Sizewell C DCO Application-PINS ref: EN010012

## Post D10 comments on Sizewell C DCO submissions in relation to adverse impacts on the marine environment

## **Annex A TASC report on document REP10-135: Comments on REP10-135 9.67 Quantifying uncertainty in Entrapment Predictions for Sizewell C**

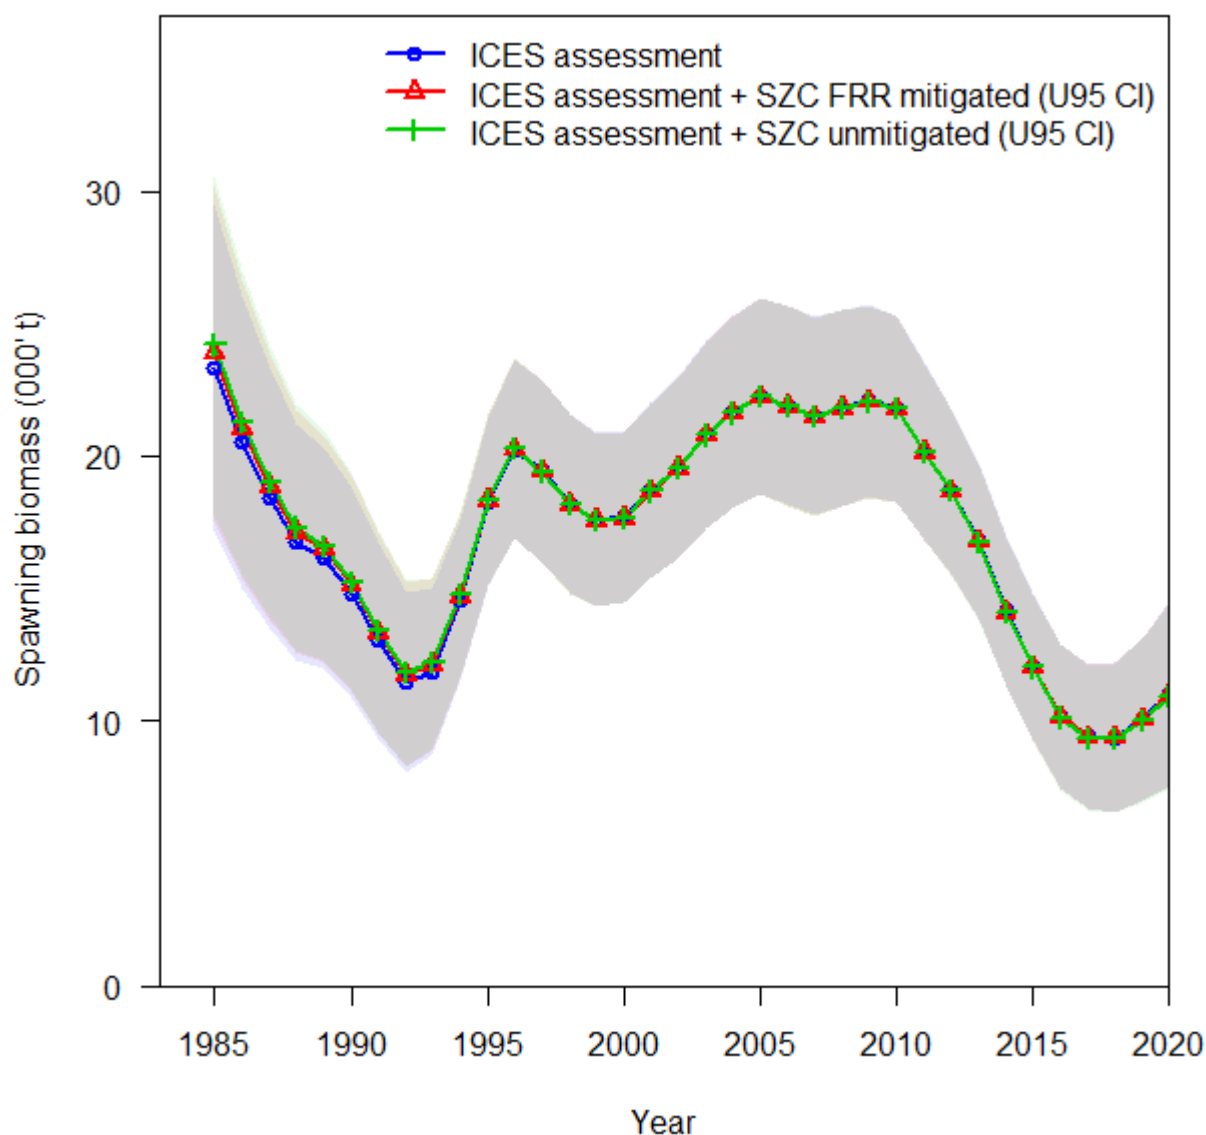
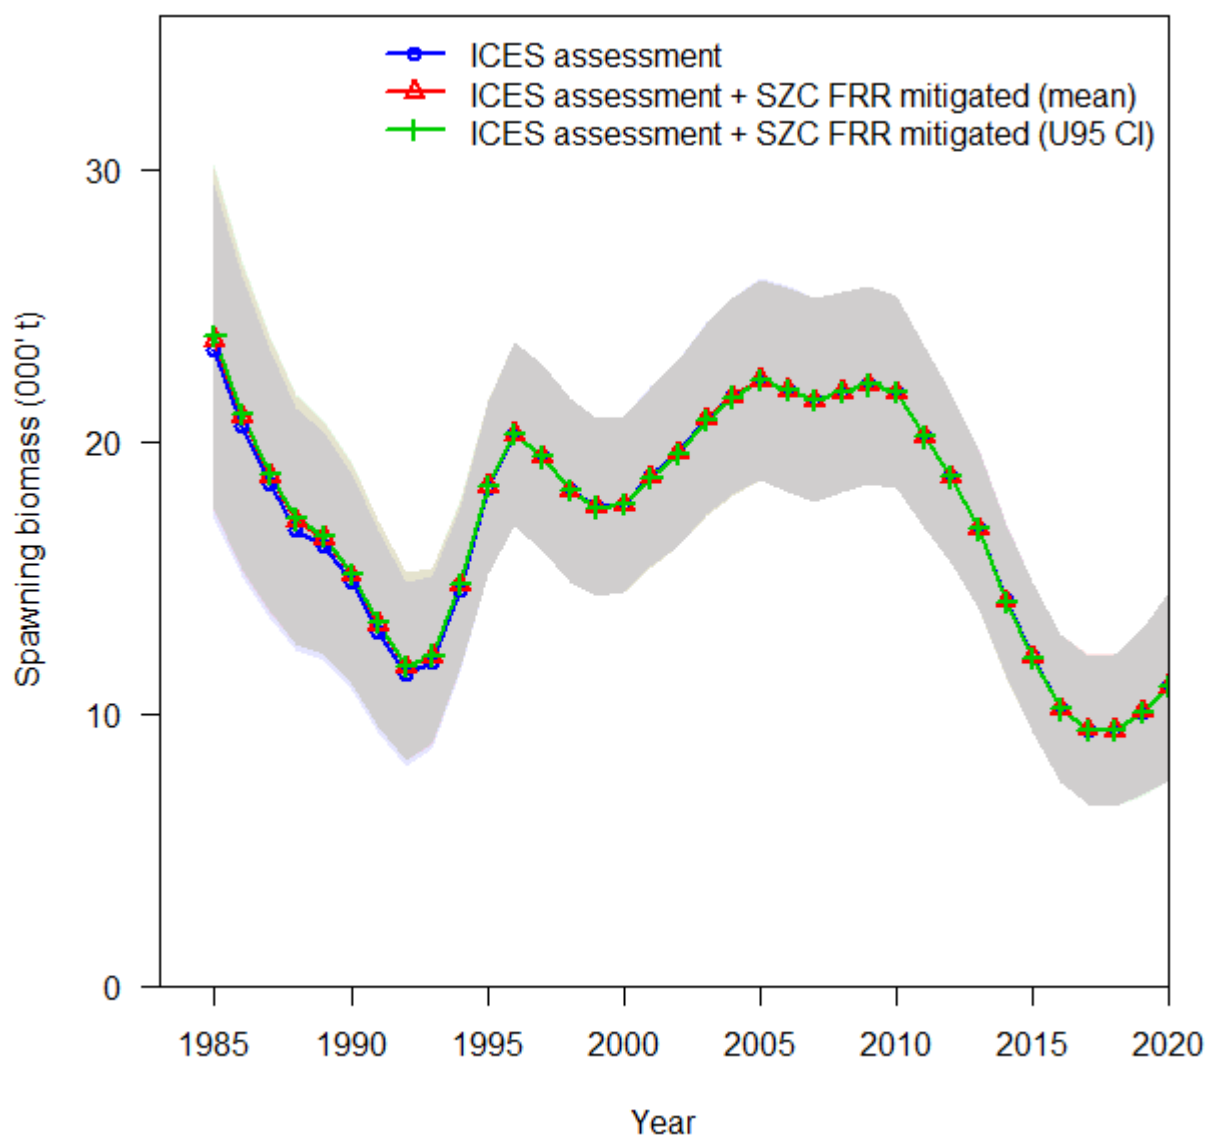
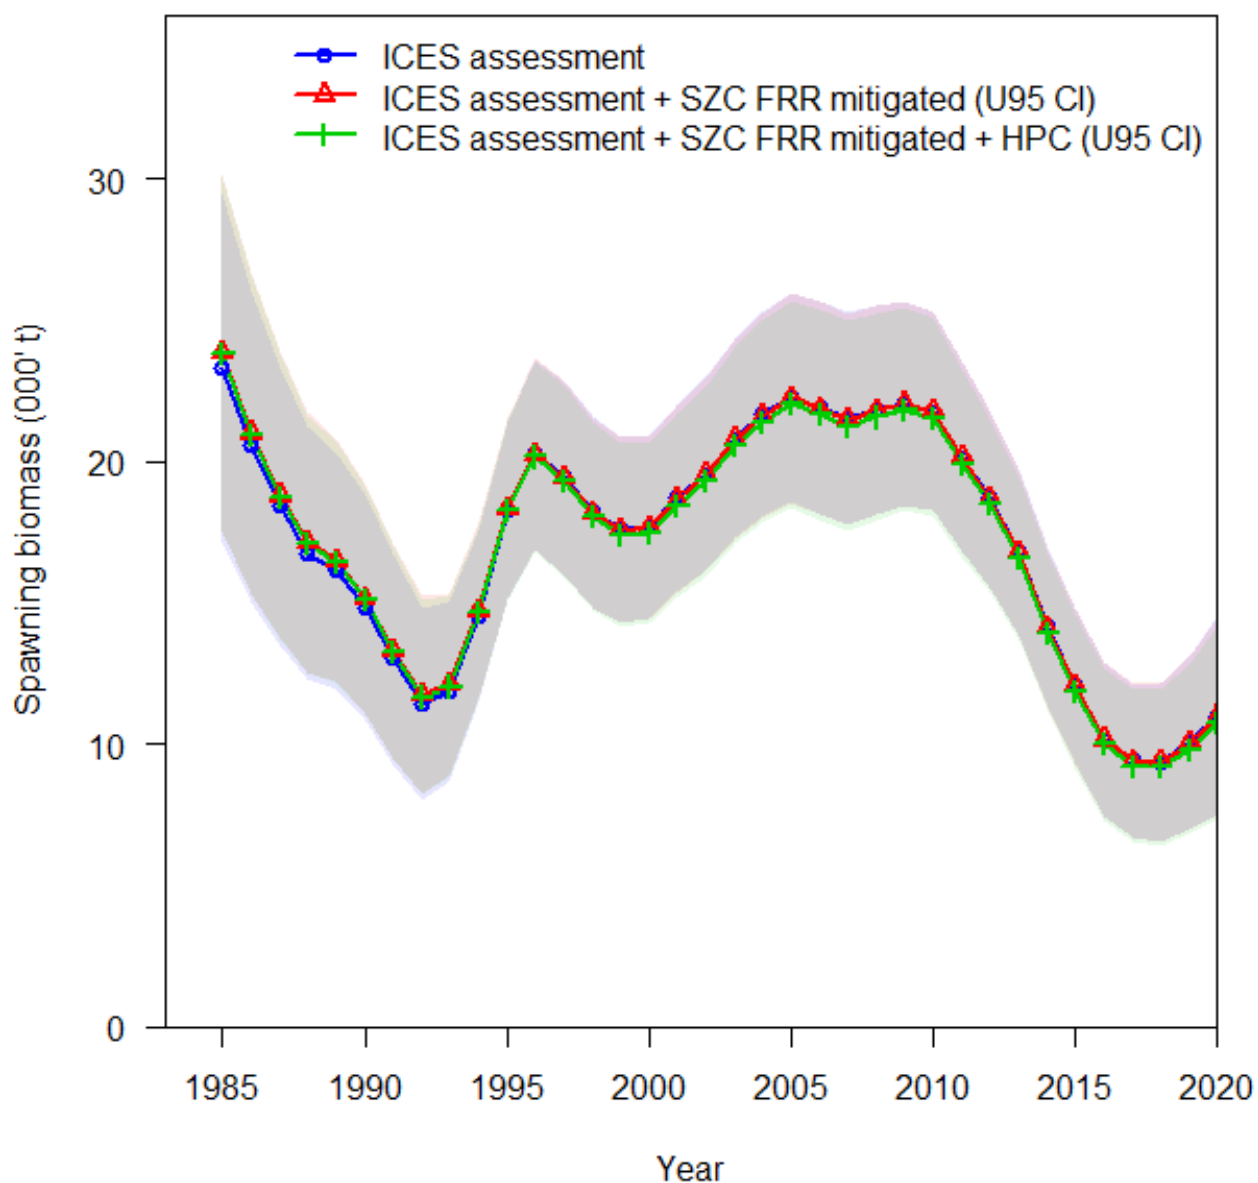
TASC consider the Applicant/CEFAS's sea bass assessment, in only addressing impingement, under-assesses the impact on the sea bass population due to entrainment. Bass spawn offshore and the young fish move into estuaries to feed and grow. However, during the winter they move out of estuaries to warmer sea water and so quite small bass occur off Sizewell. It is highly likely that bass less than 14 mm deep in the body occur at Sizewell and these are capable of penetrating a 10 mm mesh. A 2018 CEFAS document

conclusion on page 65 states: *"There is good evidence that the area in the immediate vicinity of the power station has sufficient aggregation of juvenile sea bass to give a high probability of them being impinged by the cooling water intakes, although individuals of other species above MCRS are present (Table 5). Hence, there is evidence to support further consideration of the proposed Sizewell BNA (Table 5)."* TASC find it hard to understand how CEFAS can consider Sizewell as a BNA but then support the slaughter of bass through the SZC CWS. It is clear that the number of bass entrained has not been quantified by the Applicant/CEFAS.

(vi) As the sea bass assessment has not considered entrainment, it is incomplete.
